PORTLAND MAINE

February 12, 2010

Re: 12 Tarbell Street – 332 E038 – R-3 – illegal deck & 16' x 20' single story addition – permit #09-1235

<b>PLOT PLAN</b>	
SCALE: 1/4" = 1'	APPROVED BY:
DATE: OCT 29 09	DRAWN BY: JUDY ALLEN/AS
BEDROOM ADDITION 16X20	
OWNER: GREGORY GAY 12 TARBELL ST	
PARL AND 318	
DRAWING NUMBER	I

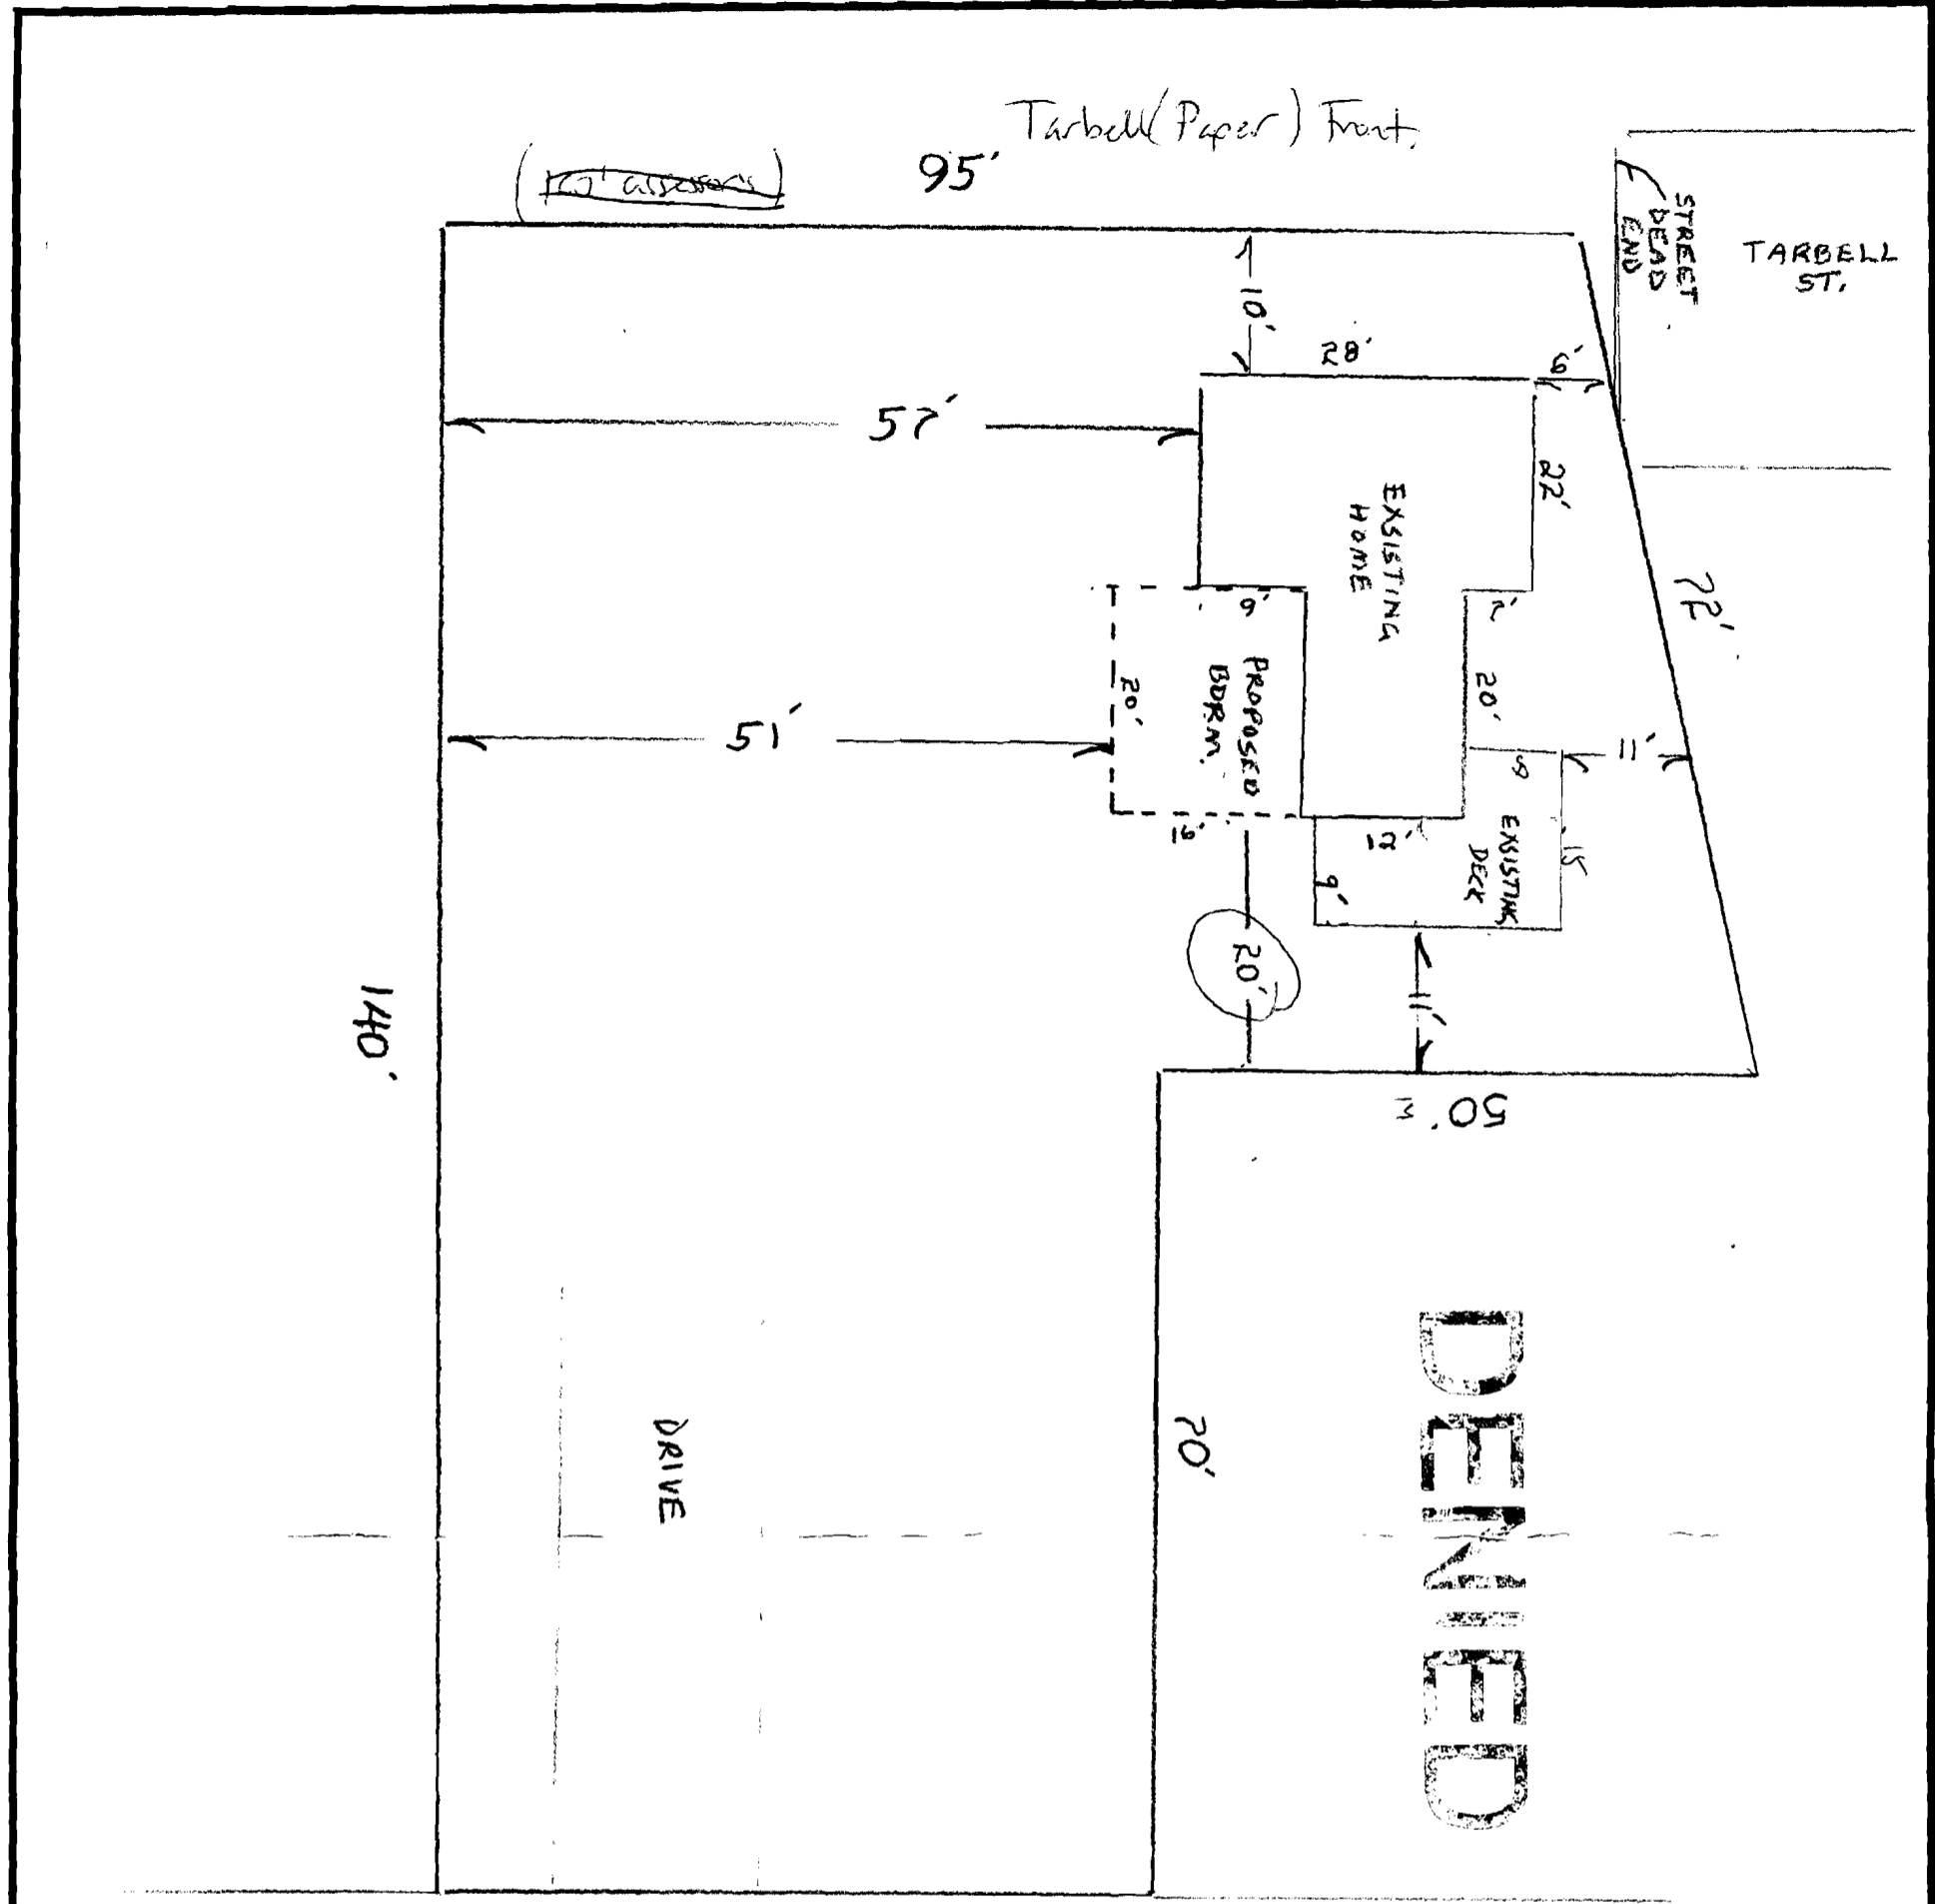
This letter is a follow up to the two previous letters that I sent you on November 18, 2009 and January 8, 2010. As you know, the existing deck on the rear of your house was never permitted and does not meet the zoning requirements of the R-3 zone (section 14-90). Since it was not permitted and does not meet the zoning requirements, it needs to be removed to bring your property into compliance.

Also, your building permit to build a single story, twenty by sixteen foot addition on the rear of the house cannot be issued at this time because it does not meet the zoning requirements of the R-3 zone. Your thirty day period to appeal this denial also was up on February 8, 2010. If you still want to build an addition, you need to revise your plans so that the zoning requirements can be met. If you don't want to modify your plans, you can withdraw your application and get most of your money back.
